CITY OF ALBUQUERQUE

**Re: Route 66 Plaza
8521 Central Ave NE
30-Day Temporary Certificate of Occupancy- Traffic Certification Only
Transportation Development Final Inspection**
Engineer's/Architect's Stamp dated 5-17-16 (K19D043)
Certification dated 2-5-19

A SITE PLAN
SCALE: 1"=10'-0"

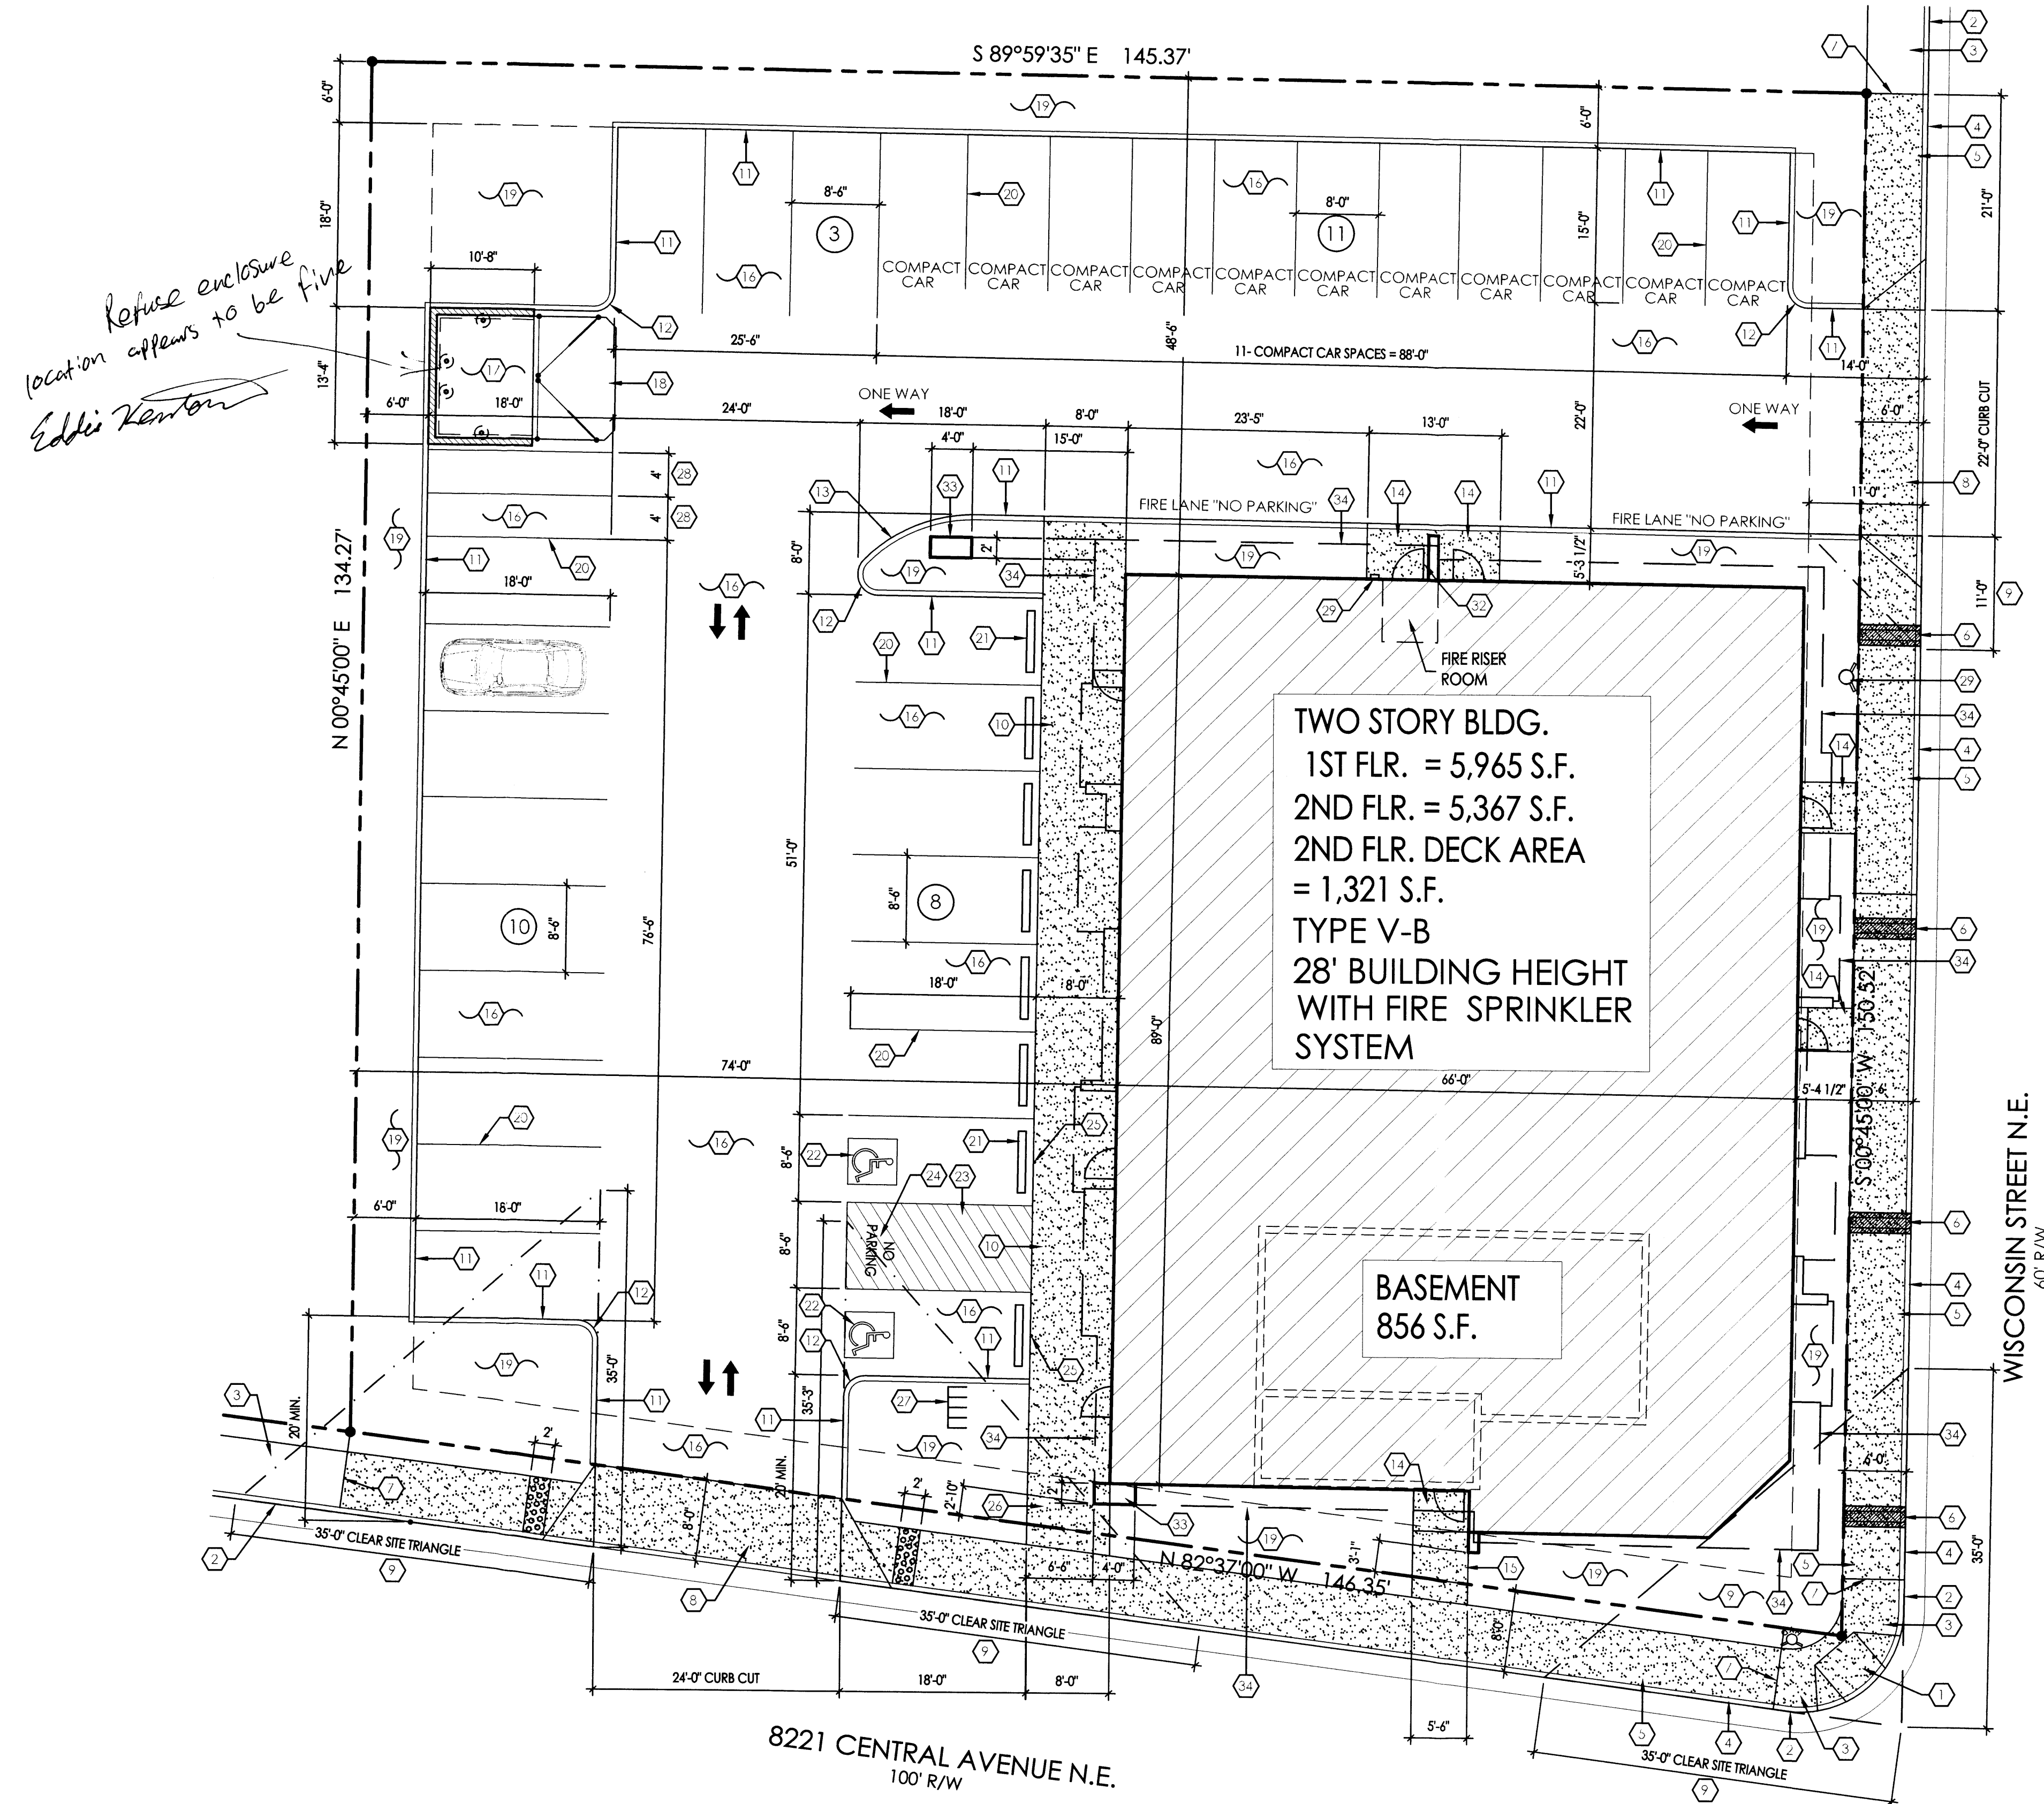
1. Please add bike rack per approved plan.
2. Please add wheel stops to the two ADA spaces.
3. Please send photos of corrections to PLNDRS@cabq.gov when requesting Final CO.
